Application for approval of details reserved by condition imposed on planning permission
WA/28/14/PL relating to condition 10 (Travel Plan Statement) and 13 (Entrance gates)

Walberton Place Care Home Yapton Lane Walberton

Thank you for your internet representation made on 12th September 2018 which has been recorded as '**an objection**' with the comments as follow s:

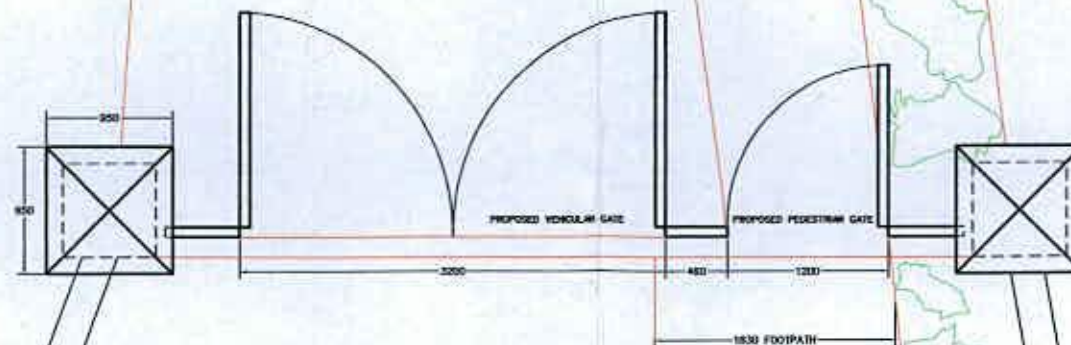
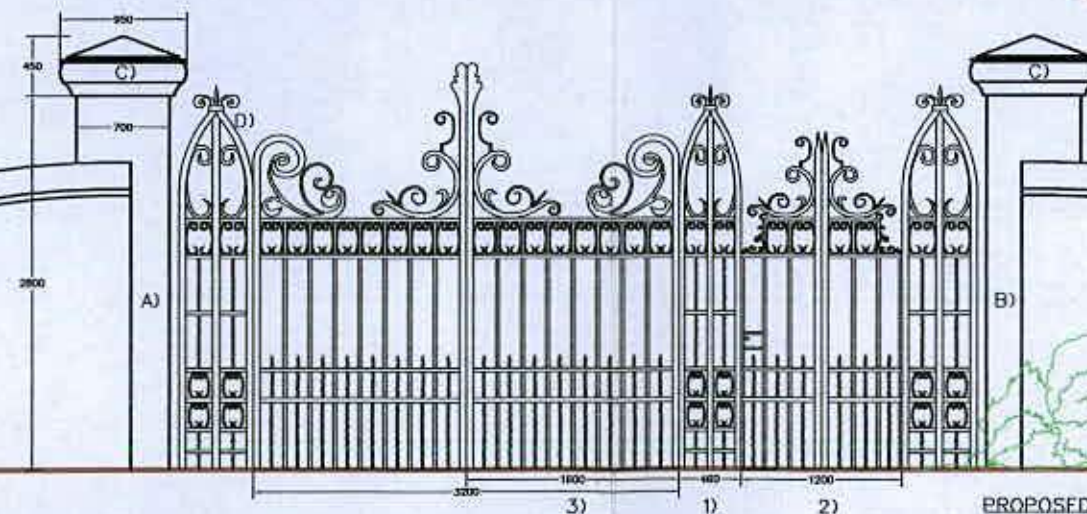
Gates - We are not unduly concerned about a separate pedestrian access as the gates are highly unlikely to be closed at any time. We agree with the conservation officer that they should be cleaned and painted. The minimum opening should be 4,400 mm to ensure that large delivery vehicles have suitable access.
